Date: 03/12/2024

Re: **Damaged Roof Trusses**
Location: Lot 23 Riverfall (110 Denali Dr. Angier, NC)
JDS Project No.: RDU2402606
Date of Inspection: 03/12/2024

Drawing file: SFD2401-0020 / 23 RVF - Truss Layout (12-15-23).pdf

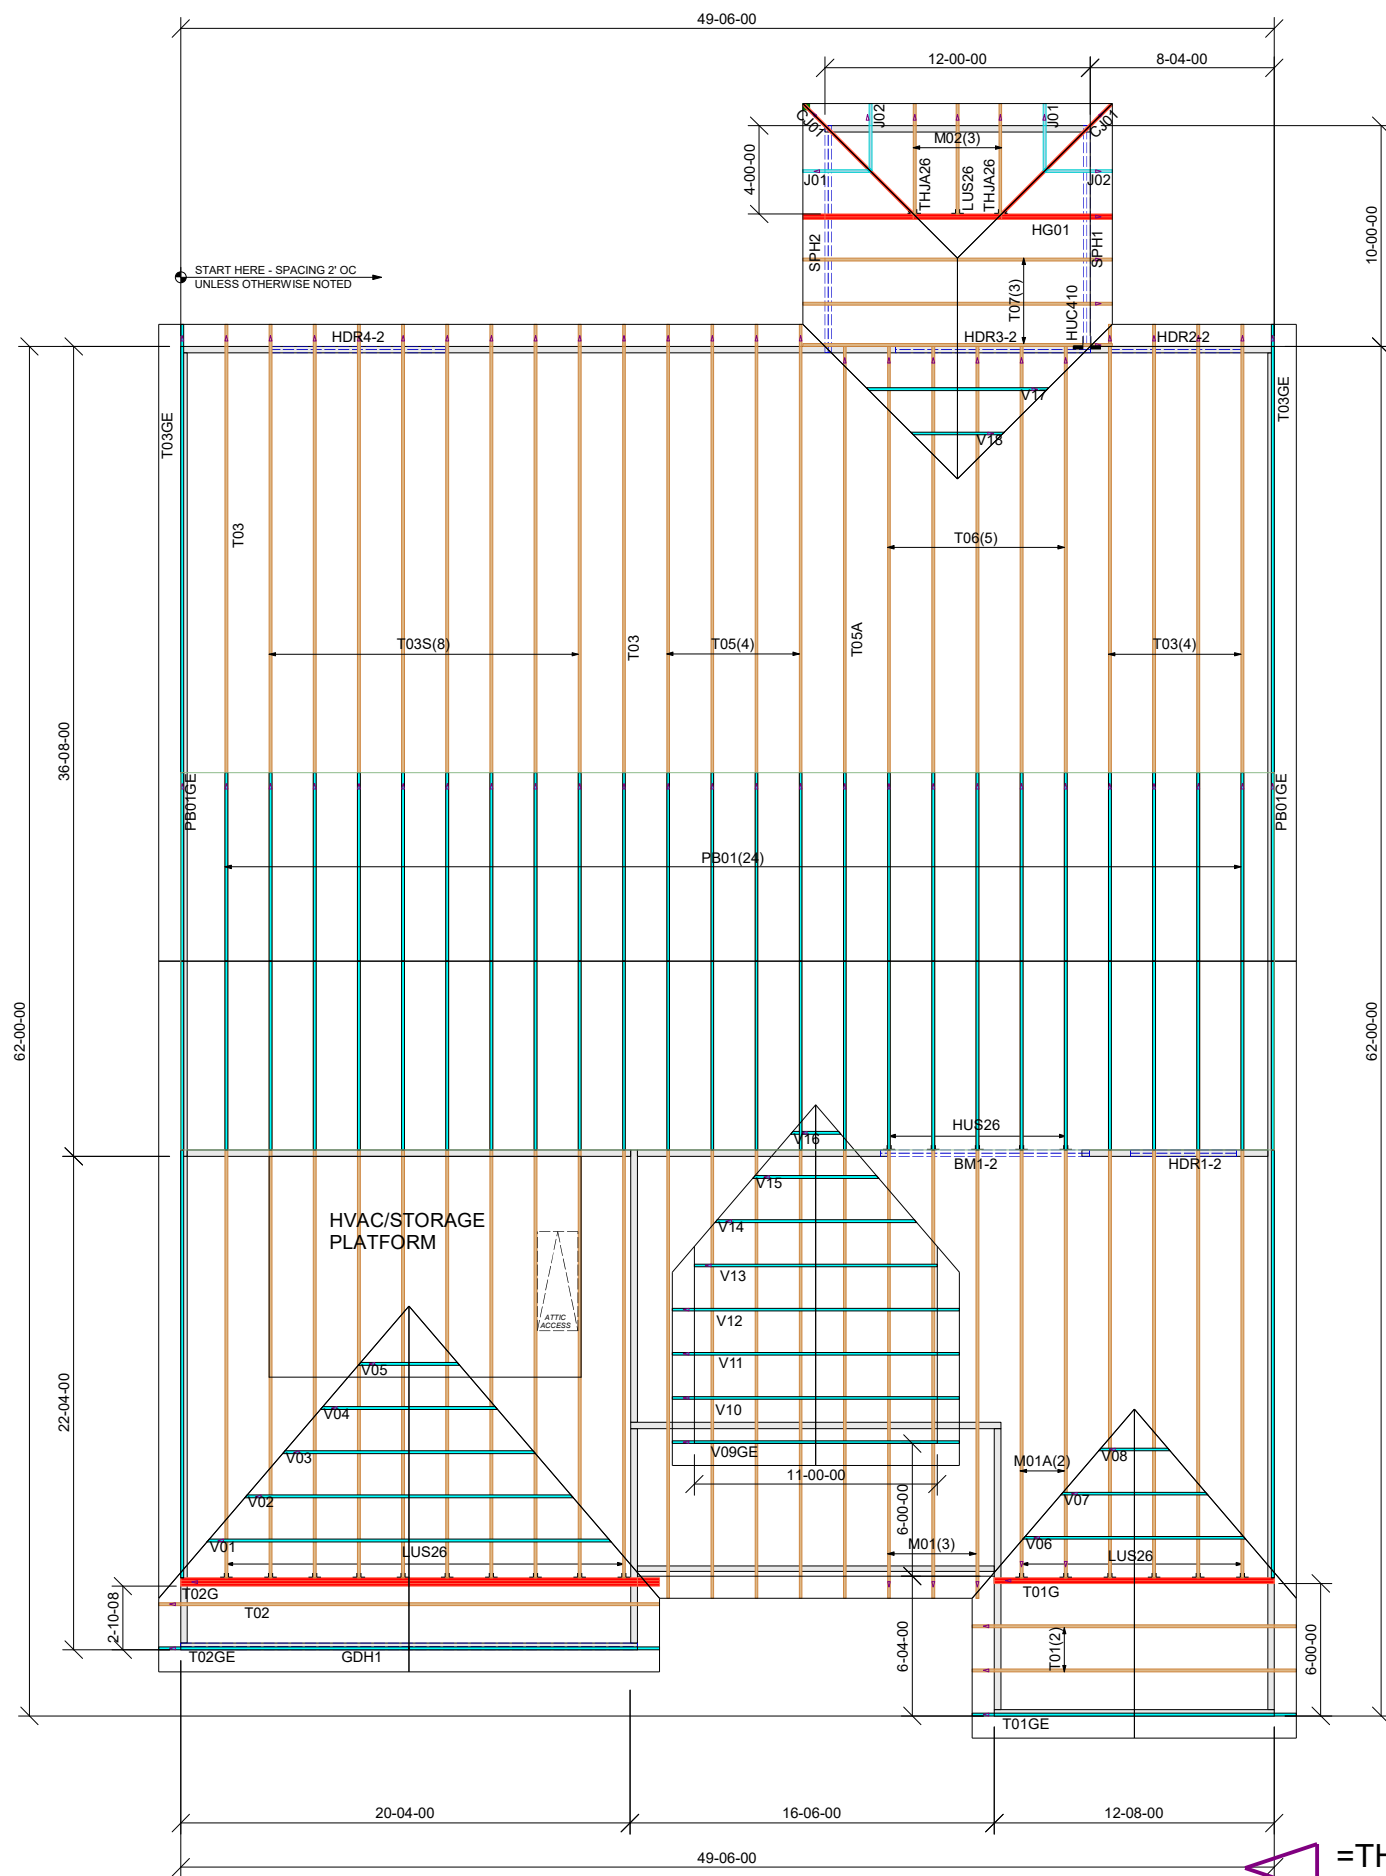
The client requested evaluation of several issues with the T03S trusses. It was observed that:

- 1) The 1st T03S truss from the left exterior wall has pulled gussets at joint 8 on the left side, and joint 7 on the right side.
The 2nd T03S truss from the left exterior wall has pulled gussets at joint 7 and joint 8 on the right side.
The 4th T03S truss from the left exterior wall has pulled gussets on both sides of joint 7, and one side of joint 8.
- 2) The 2nd T03S truss from the left has a crack in the top chord between joints 6 and 7. A 6' long scab was installed, but the nailing pattern was unable to be determined.
- 3) While on site it was also observed that the T03S trusses hanging at the girder truss at the front of the garage had hanger gaps that were too large (between 3/8" and 3/4"), in T03S trusses 1 through 9 from the left exterior wall.

- 1) For each of the 1st, 2nd, and 4th T03S trusses with damaged gussets at joint 7 and 8:
 - a. Install a 6' long 2x6 scab on both sides of truss centered on joint 7 and 8. Attach with (3) rows of 10d nails spaced 4" o.c., staggered through both sides.
 - b. Then fur out on both sides of the vertical web below joint 7 with 2x4 blocking, attached with (2) rows of 10d nails spaced 4" o.c.
 - c. Then attach a 24"x24"x7/16" OSB gusset plate to both sides of the furred out truss, centered on joint 7, top edge flush with the top of the truss. Attach with (3) rows of 10d nails spaced 4" o.c. through the top chord, and (2) rows of 10d nails spaced 4" o.c. through the vertical web.

- 2) For the 2nd T03S truss with a crack in the top chord between joints 6 and 7, install a second 6' long 2x6 SP No. 2 scab on the other side of the truss centered on the crack. Attach with (3) rows of 10d nails spaced 4" o.c.
Add additional nails in existing scab to achieve (3) rows of 10d nails spaced 4" o.c.
- 3) At the front bearing end of each of the leftmost (9) T03S trusses, install a 6' long 2x6 scab along the bottom chord on both sides of the truss, with one end flush against the girder. Attach to the bottom chord with (3) rows of 10d nails spaced 4" o.c. Then attach each scab to the girder with a Simpson L70 angle.
